Appeal Decision

Appeal Ref: APP/A2525/D/23/3334715

75 Bourne Road, Spalding, Lincolnshire PE11 1JR

- The appeal is made under section 78 of the Town and Country Planning Act 1990 against a refusal to grant planning permission.
 - The appeal is made by Mr D Roberts against the decision of South Holland District Council.
 - The application Ref H16-0727-23, dated 10 August 2023, was refused by notice dated 10 October 2023.
 - The development proposed is described as 'Removal of existing conservatory and replace with one and half storey extension (renewal of H16-1143-07) and proposed carport (retrospective).'
-

Site Block Plan
1 : 250

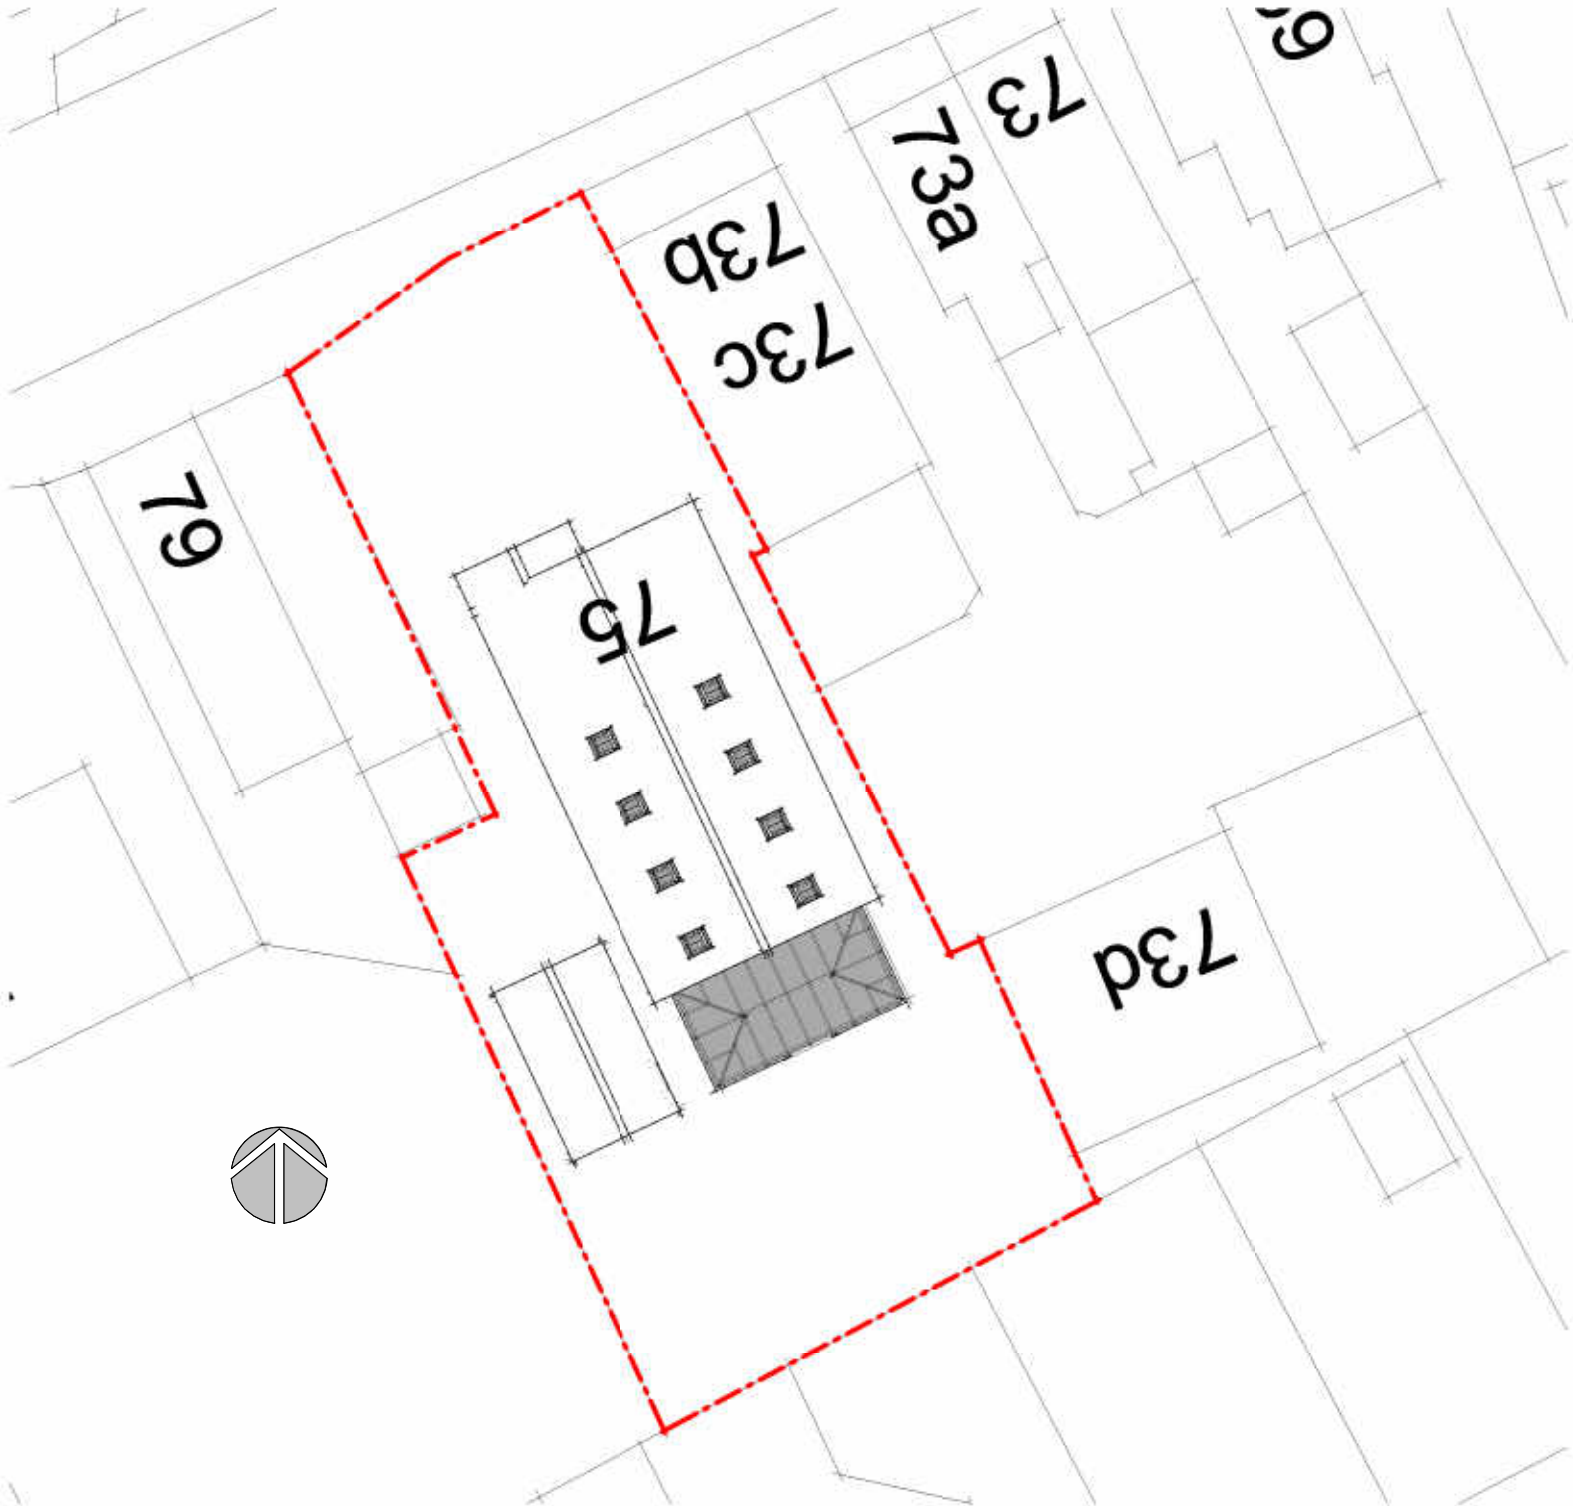
10. The carport as constructed is very large and takes up much of the front garden area and would be unlike anything in the surrounding area. The carport would be unusual in its size, location, and dominance within the street scene which accentuates the poor appearance and clutter already experienced as a result of the hard standing and vehicular parking area. Whilst I agree that the use of timber is an appropriate material for such a carport, this does not overcome the dominant form and appearance of the car port which does not reinforce the positive character, appearance and local distinctiveness of the area.

12. No.73 C/D is an apartment that is set forward within the plot compared to the appeal site. Unusually, the main and only window to the Kitchen/diner of the neighbouring property is within the front garden area of the appeal site and requires this third party land for its access to natural light. The carport, although having open sides, the roof does cause a significant amount of overshadowing and loss of light to this window of the neighbouring property, which is its only window.

1. The appeal is dismissed insofar as it relates to the carport.
2. The appeal is allowed insofar as it relates to the removal of existing conservatory and replace with one and half storey extension; and planning permission is granted for the Removal of existing conservatory and replace with one and half storey extension at 75 Bourne Road, Spalding, Lincolnshire PE11 1JR in accordance with the terms of the application, Ref H16-0727-23, dated 10 August 2023, so far as relevant to that part of the development hereby permitted and subject to the following conditions:
